East Anglia ONE North and East Anglia TWO Offshore Windfarms

Applicants' Comments on SASES' Deadline 7 Submissions

Applicant: East Anglia TWO and East Anglia ONE North Limited
Document Reference: ExA.AS-22.D8.V1
SPR Reference: EA1N_EA2-DWF-ENV-REP-IBR-001017

Date: 25th March 2021
Revision: Version 01
Author: Royal HaskoningDHV

200

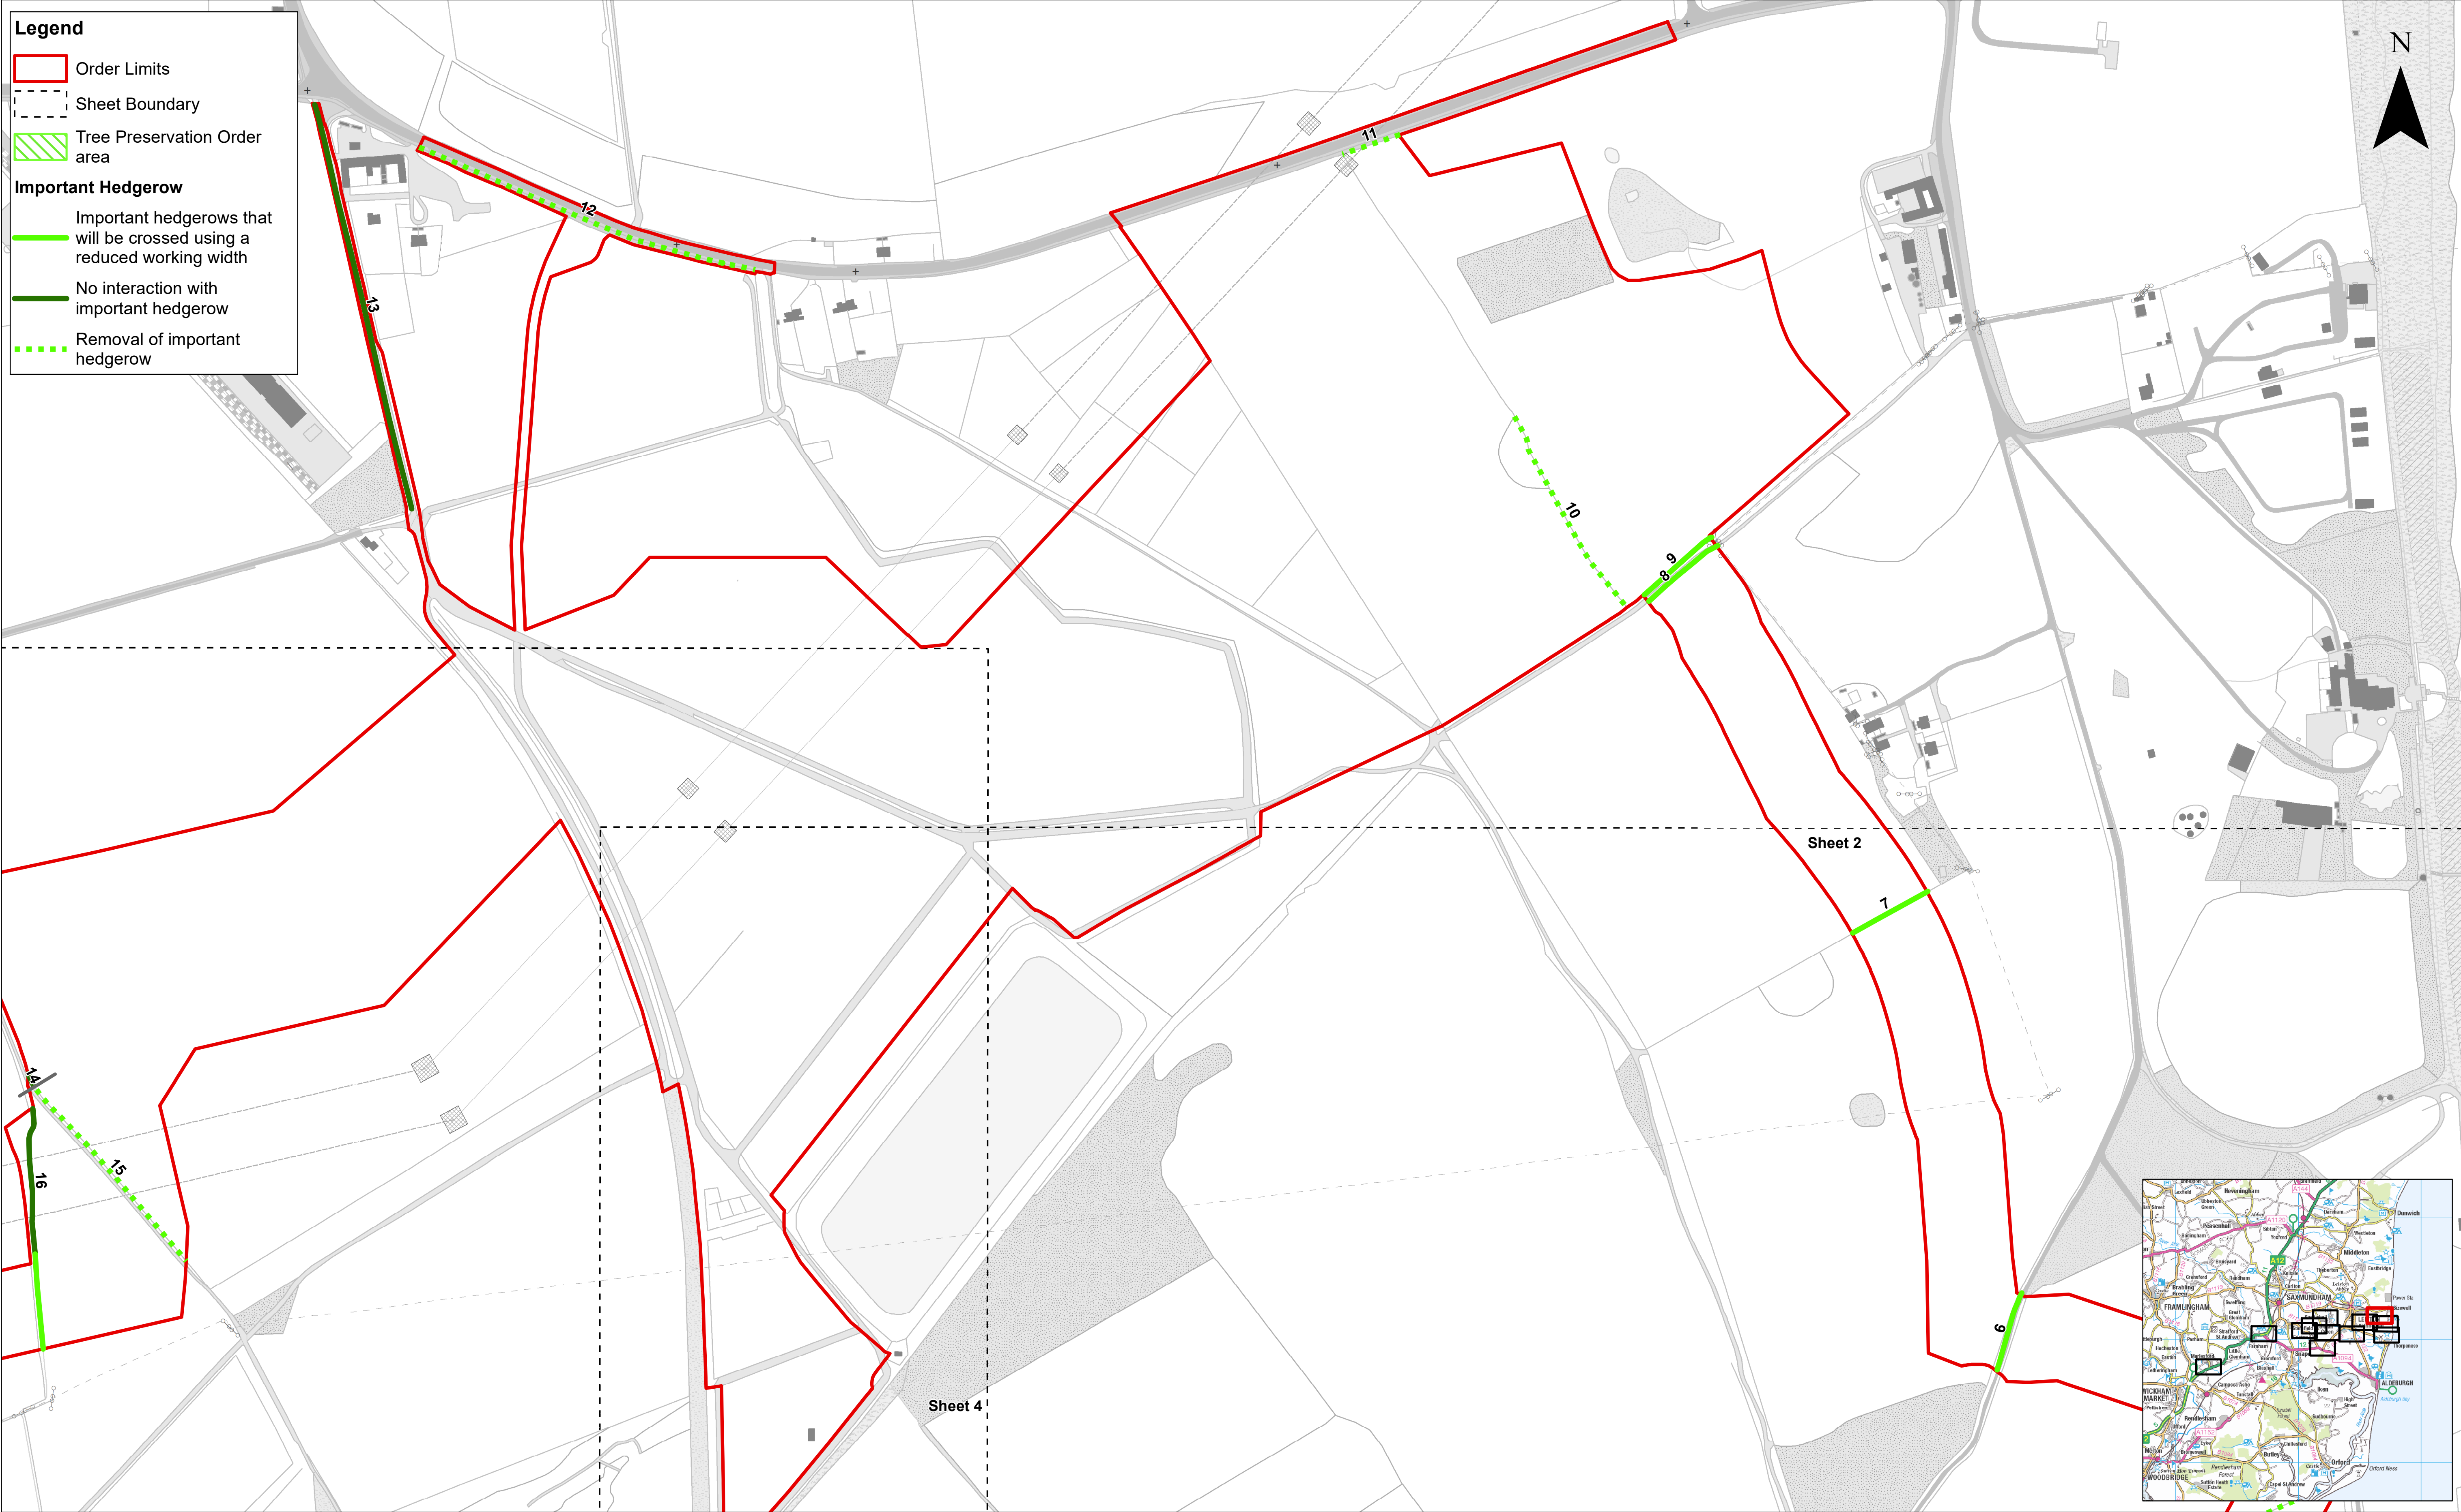
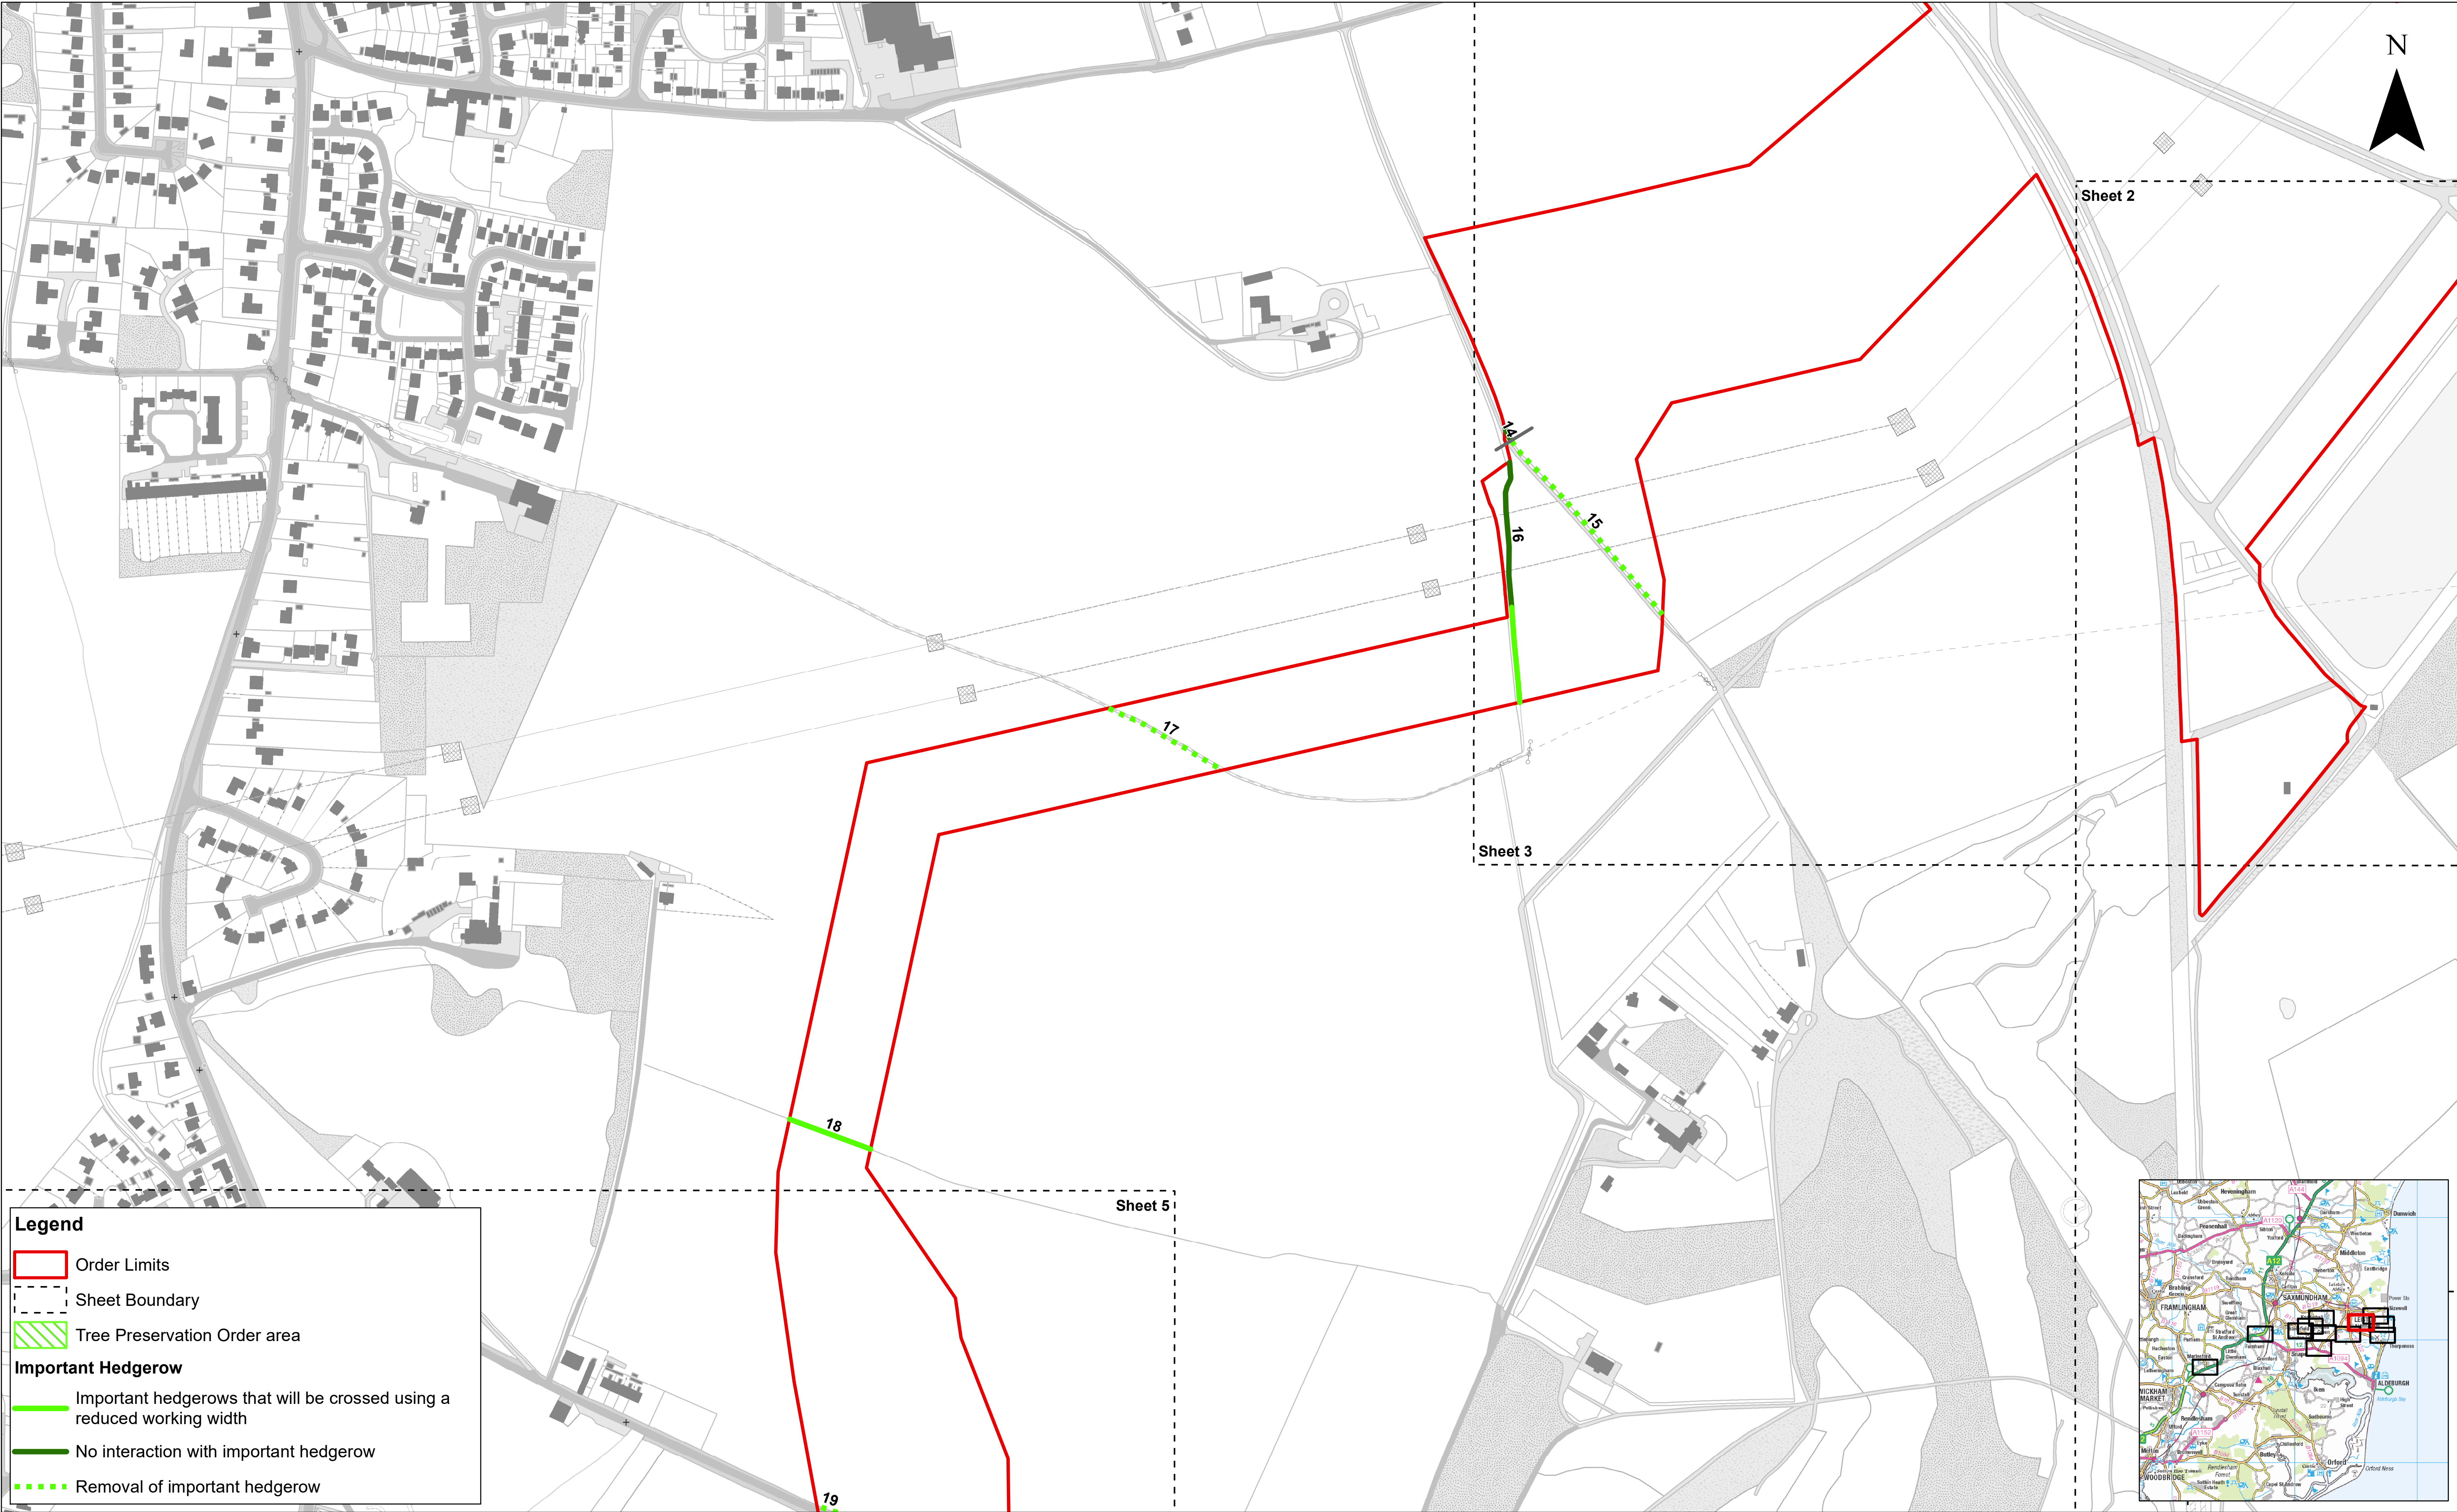
ID	SASES' Comment	Applicants' Comments
	 <p data-bbox="344 1034 846 1066"><i>Hedgerow 5 (running west from wooded pit)</i></p>
